# HARNETT COUNTY

August 31, 2001

RE: Status of Improvement Permit Application

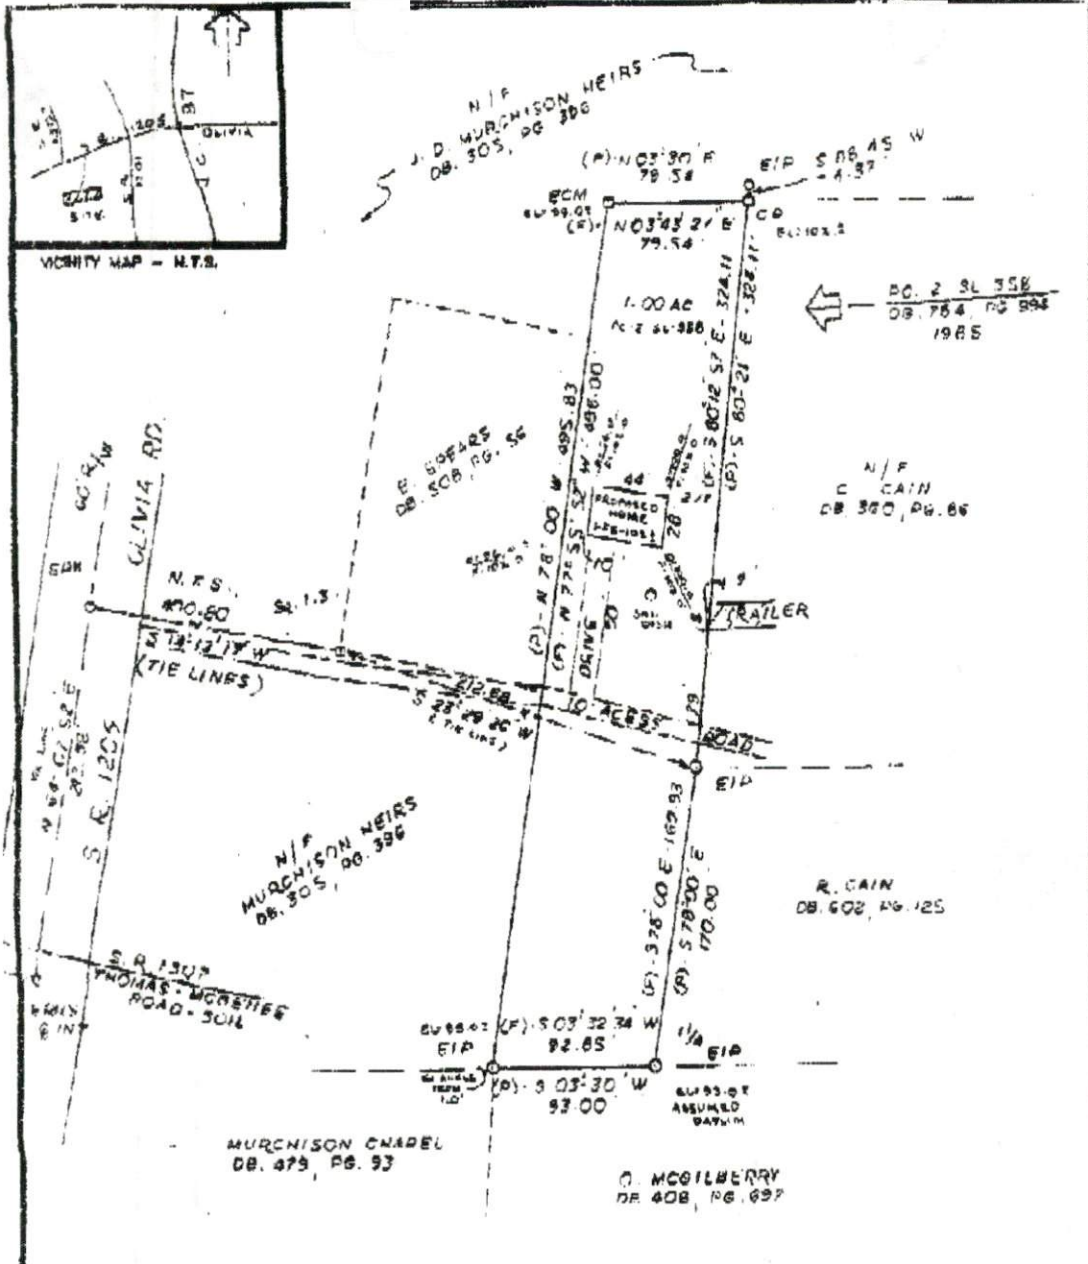
- 1. Property lines/corners not marked or labeled
- 2. House corners not marked or labeled
- 3. Directions not clear to the property
- 4. Property needs brush or vegetation removed
- 5. Backhoe pits required
- 6. Other Map show lot off of Olivia Road, directions say Murchison Town Road, which is correct, I cannot find it.

*MUST Provide  
Recorded  
Survey  
MAP  
9-6-01*
